**Consultation Response from KC,
Trees****2023/91513 25, Bishops Way, Meltham, Holmfirth, HD9 4BW****Erection of two storey side extension****Date Responded:16/08/23****Responding Officer:M Moss****Responding Ref:50/95**

Application 2023/91513 – Resubmission which is currently pending determination

PROPOSED SITE PLAN

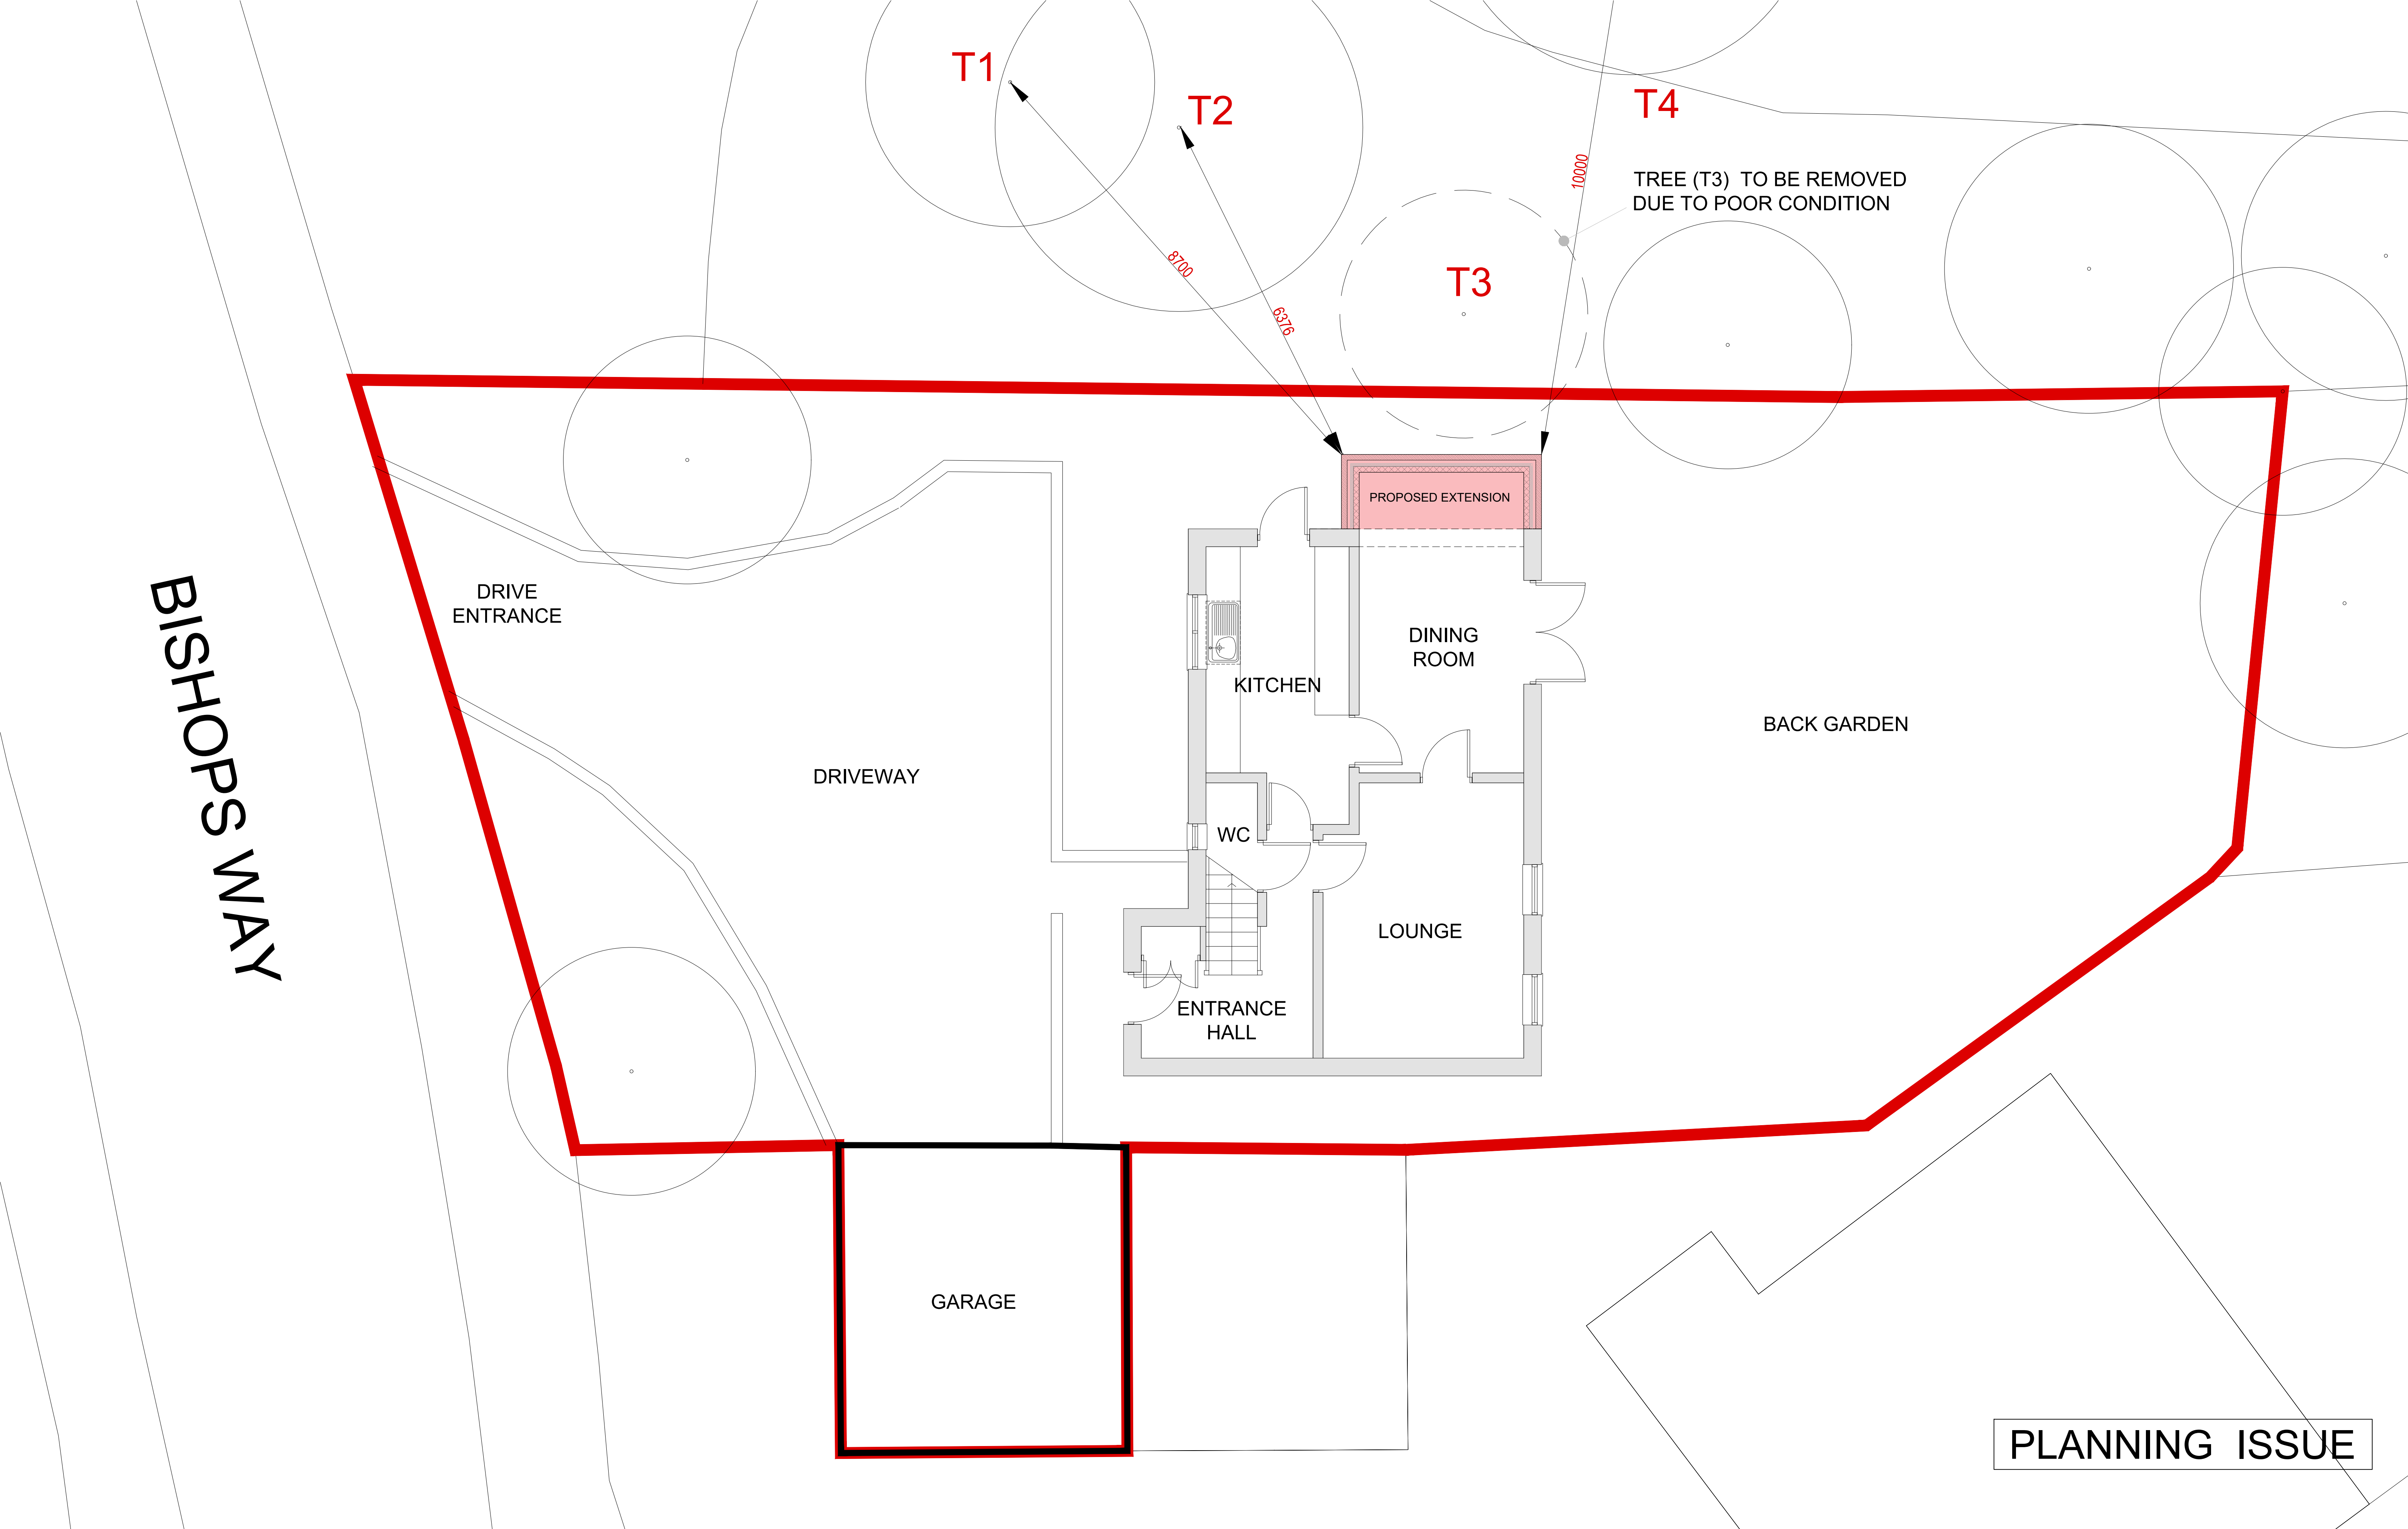
As discussed, the proposal will incorporate the removal of one tree (tree 3 on the above plan).

Given the amended scheme, in terms of being further from the boundary, and fact the only opening proposed would serve a bathroom, the previous reason for refusal appears to have been suitably addressed.

Yes, I agree that this reduction of the proposed extension and removal of the double opening is an improved design that will create less of an ongoing conflict with the adjacent tree line and therefore is more acceptable from a trees point of view.
